KITITAS COUNTY

DEPARTMENT OF PUBLIC WORKS

SUBJECT: SP-22-00004 Willard Preliminary Short Plat Comments

HAYBROOK FARMS - PHASE 2
 PART OF GOV'T LOT 3, SECTION 30, T. 18 N., R. 19 E., W.M.
 AND OF THE E 1/2 OF SECTION 25, T. 18 N., R. 18 E., W.M.
 KITTITAS COUNTY, WASHINGTON

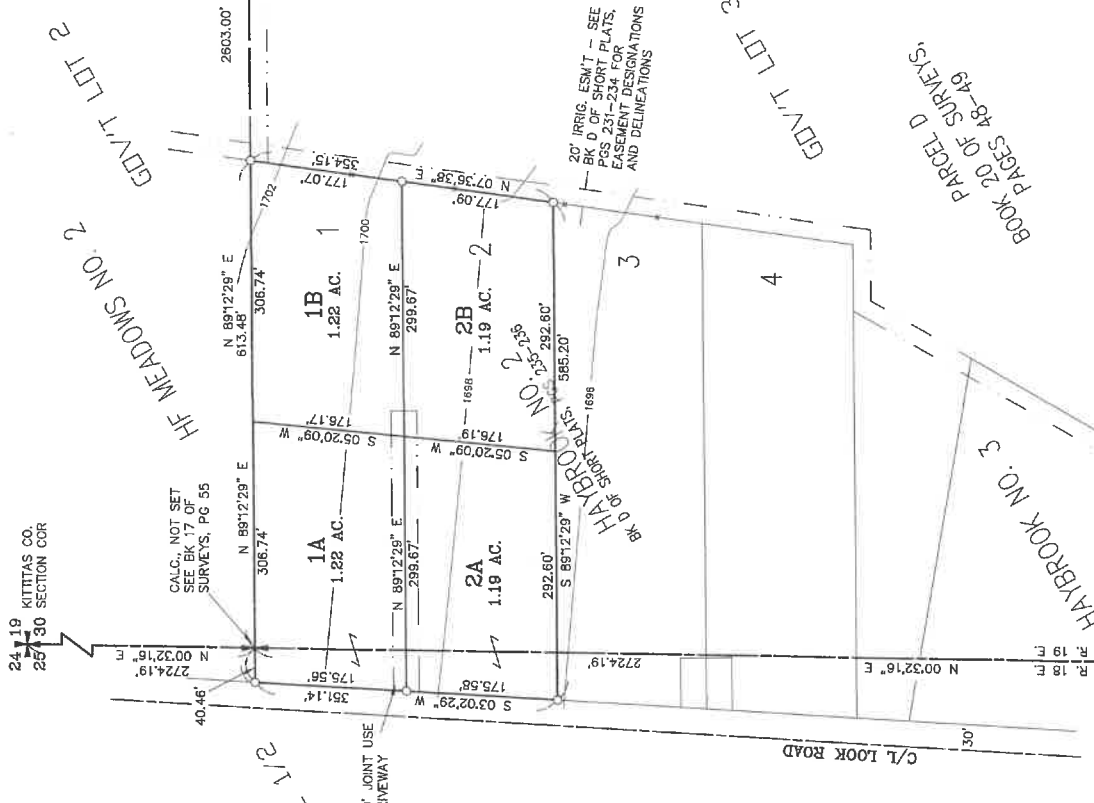
1. Lot Closure Sheet is missing (KCC 16.32.010(1)).
2. Purpose of Survey was not identified nor was the application number on the survey (KCC 16.10.020(1)).
3. Basis of Bearing was not identified on the map nor was it in the notes (WAC:332-130-050(1)(b)(iii)).
4. Roadway ownership and surfacing should be on the map.
5. If elevations or contours are to be shown, then the map must meet Topo Standards per WAC:332-130-145.
6. Irrigation easements should be shown on the map (KCC 16.12.020(11)).
7. Title report legal description does not match the legal description for original parcel description.
8. Joint-use driveway does not identify an easement. All access easements are to be shown (KCC 16.12.020(10)).
